ARBORICULTURAL STATEMENT ADDENDUM
For
Proposed construction of a block of four
apartments, with means of access and parking
within the grounds of Clayton Manor

Ribchester Road, Wilpshire BB1 9HU

Planning References
3/2023/0930
2/2010/0414
3/2013/0759

Report Ref:
DTCL.298.AMS.(2).2024

PROPOSED CLAYTON MANOR APARTMENTS SITE LAYOUT

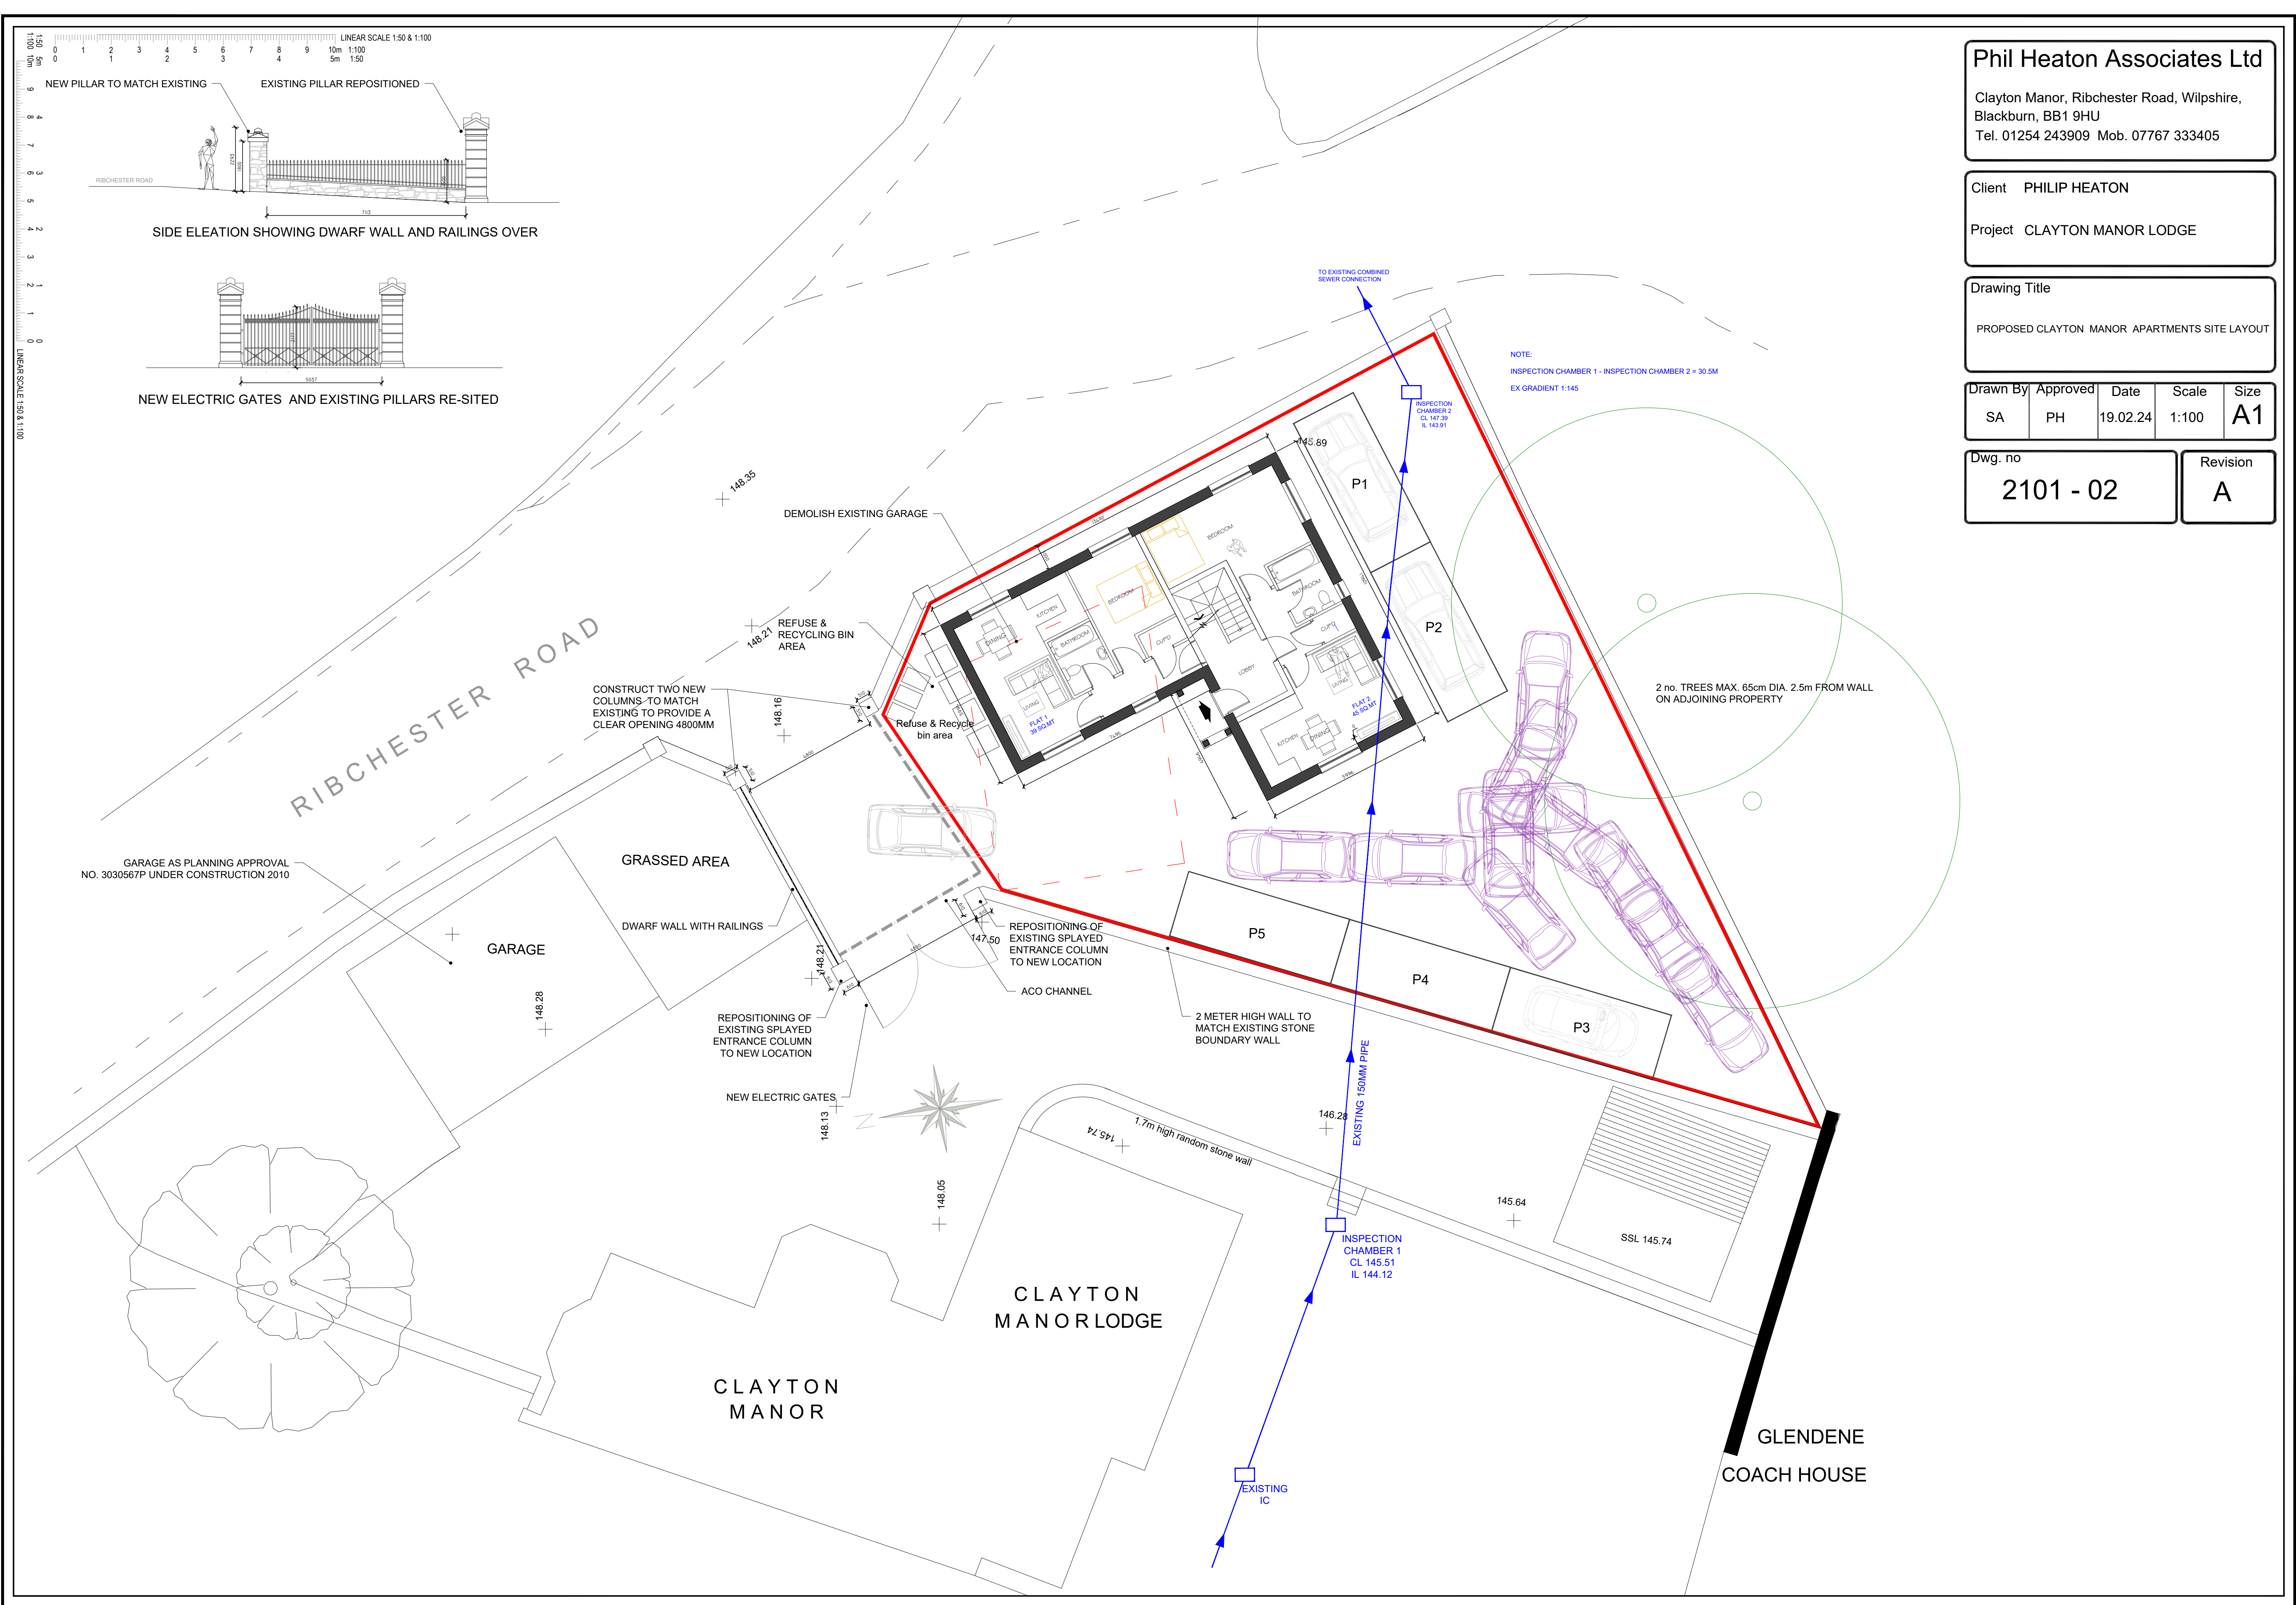
The two protected sycamore trees in question have asymmetrical crowns which nearly completely overhang the proposed parking spaces, taking this into account it would suggest that there is a high possibility the trees' root plate could extend to the adjacent garden, albeit under or through the wall.

However, as mentioned in my original email, over 60% of two of the tree's crowns overhang the proposed parking bays 1, 2, & 3, so there will always be overhanging branches unless the trees are felled or severely pruned which would be in direct contravention of BS:3998 2010 Tree Work Recommendations. Taking this into consideration I do not think the proposed carparking design is appropriate for the safe retention of the protected trees and their amenity value.

I still think an AIA is required to highlight the issues outlined above and provide recommendations of how the negative impact on the trees can be mitigated. Even if the Trial Pits reinforce Dr O'Callaghan's views, primarily due to the negative impact the parking spaces will have on the amenity values of the protected trees and potential root plate stability."

3.4.2 The claim that over 60% of the crowns overhang the proposed parking areas is an exaggeration. It is true that there is some overhang, but not as much as 60% or more, as is claimed in the Trees & Countryside response. The lower overhanging branches, i.e., up to 7 m above ground would be pruned to reduce the extent of the overhang, and this would not adversely affect the amenity value of the trees.

- 5.3 Branches of the off-site trees overhang two of the proposed parking areas to some extent, but these can be pruned back to reduce the crowns and remove the overhang.

- 5.4 Only overhanging branches up to 7 m above ground level would be pruned and all work would be in accordance with BS3998: 2010 or any future iterations of that standard. This can be made a condition of planning permission.
